33 Felpham Road
Felpham
PO22 7DA

1st March 2018

Sir
Re FP/311/17/PL

Drawing:
DESIGN PROPOSALS

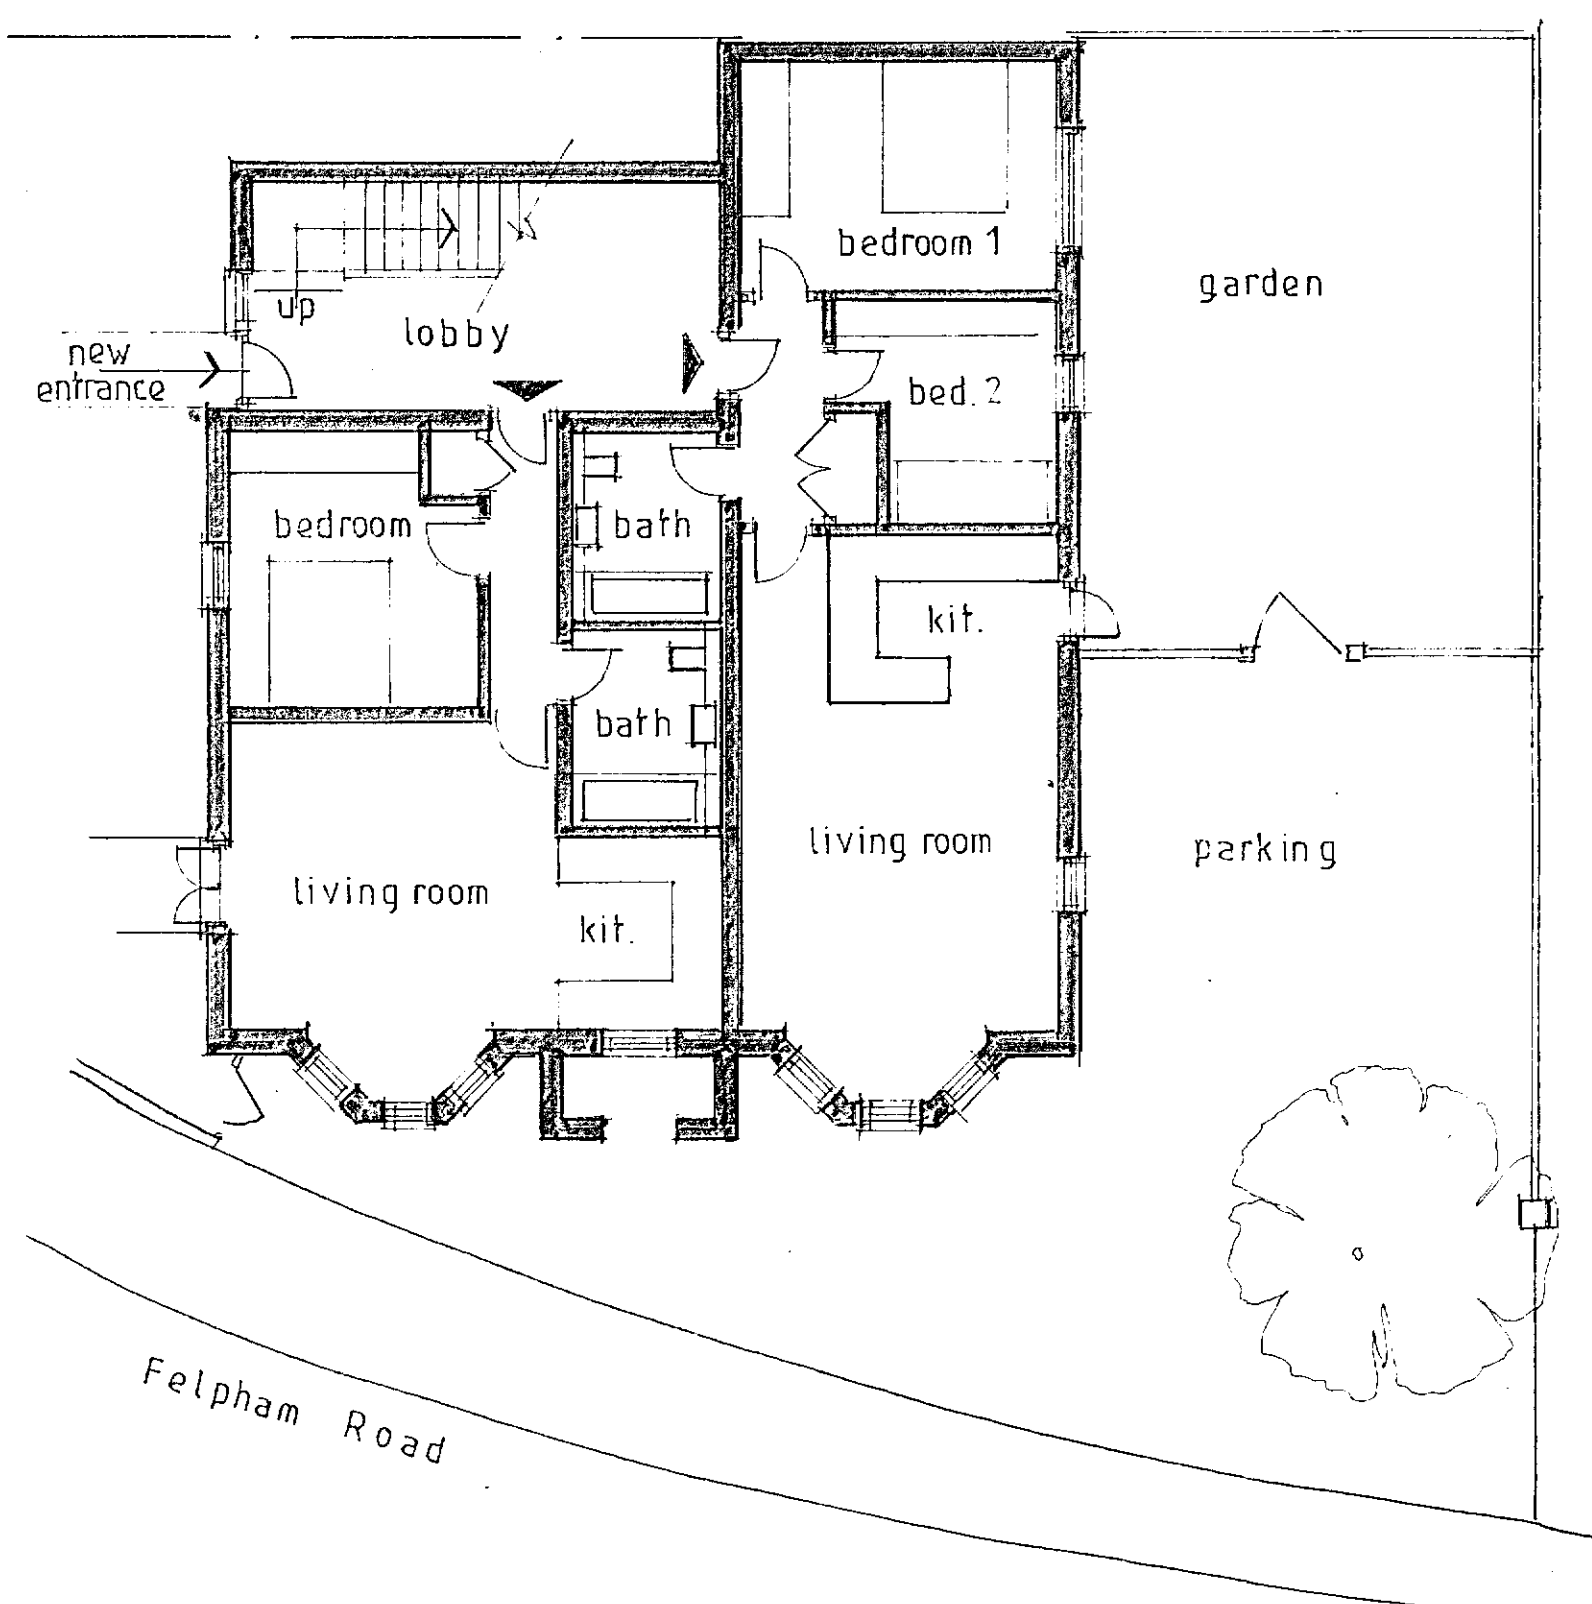
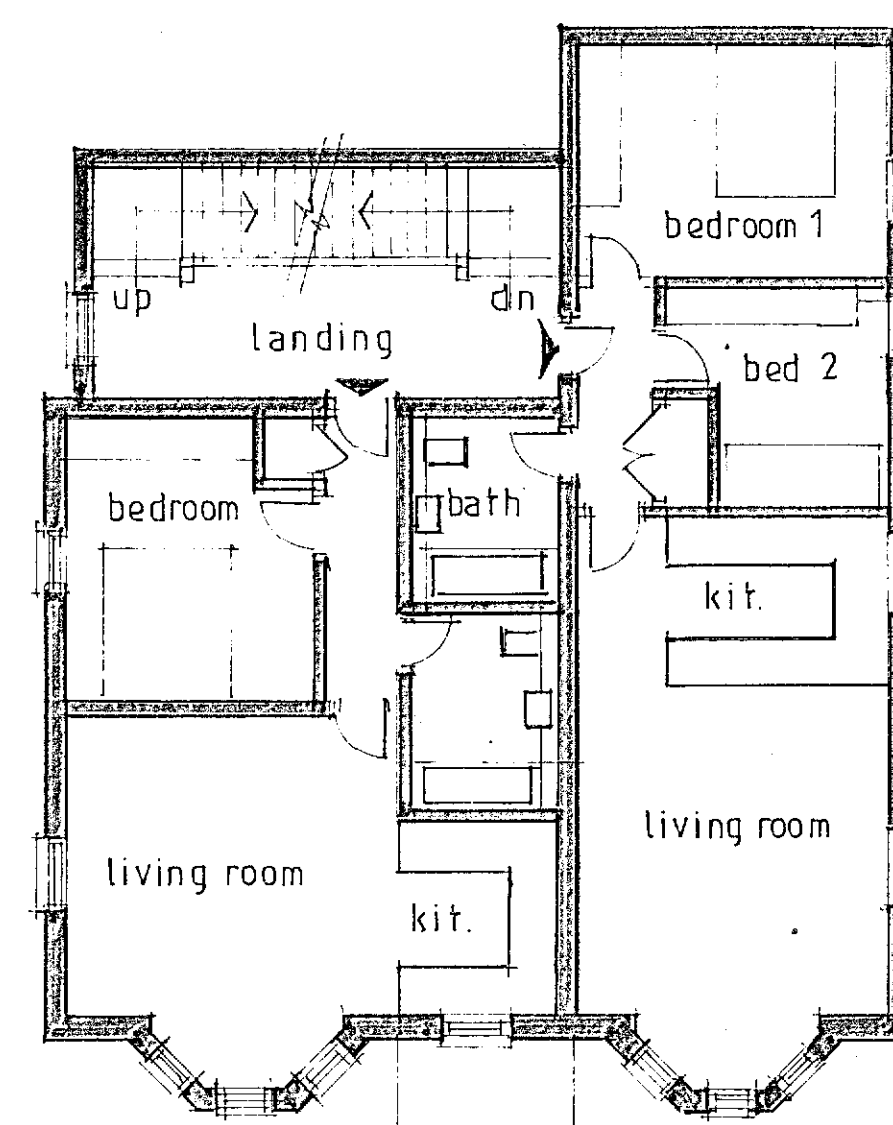
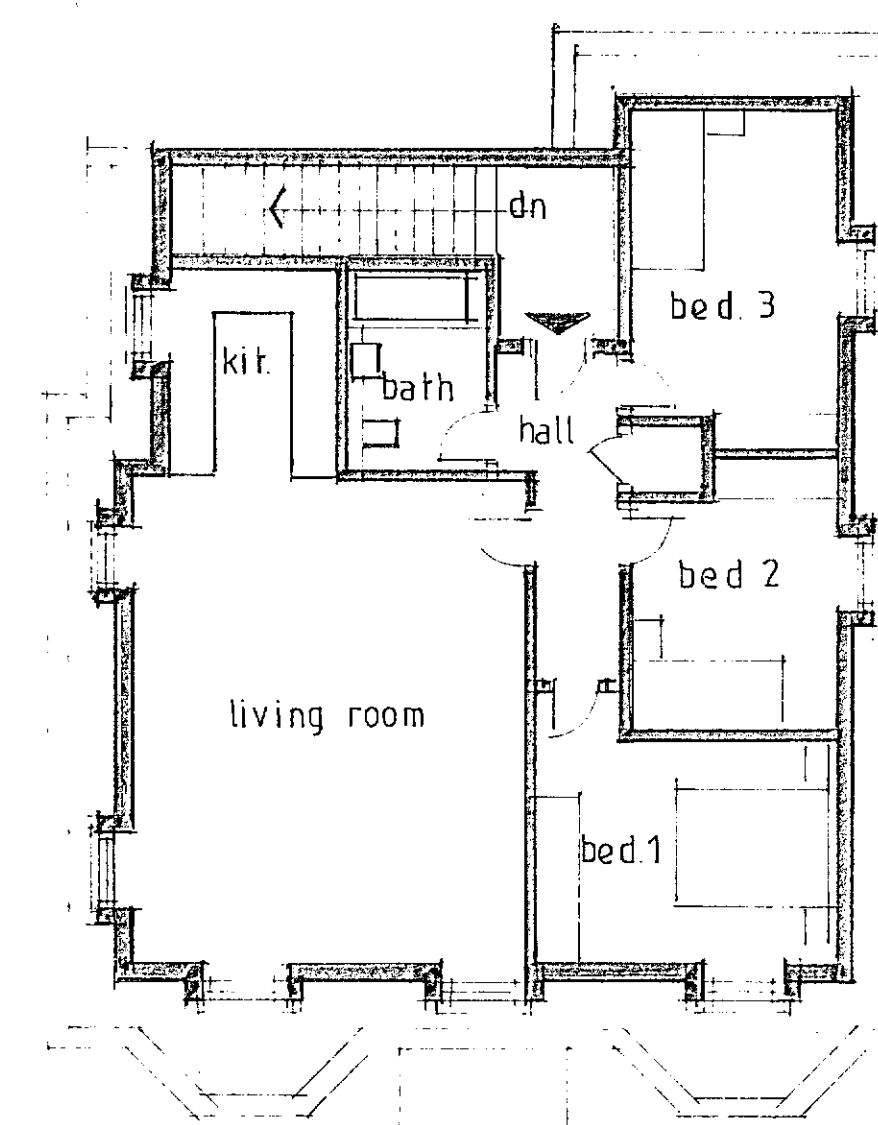
However, on reading the application I understand the owners wish to add a second floor to the building? If this is correct, I imagine the height of the building will be increased which will be totally unacceptable as it will cause serious loss of light to the front of my house and a building height in that particular location will be completely out of character in relation to the nearby properties. Further, additional occupancy of that building will require extra parking provision of which there is very little at present.

If, in fact the second floor work refers to some kind of loft conversion and would not increase the height of the building – I would request that no dormer windows are included at the front of said building which would affect the privacy of my home, ie – two front bedrooms, dining room and office.
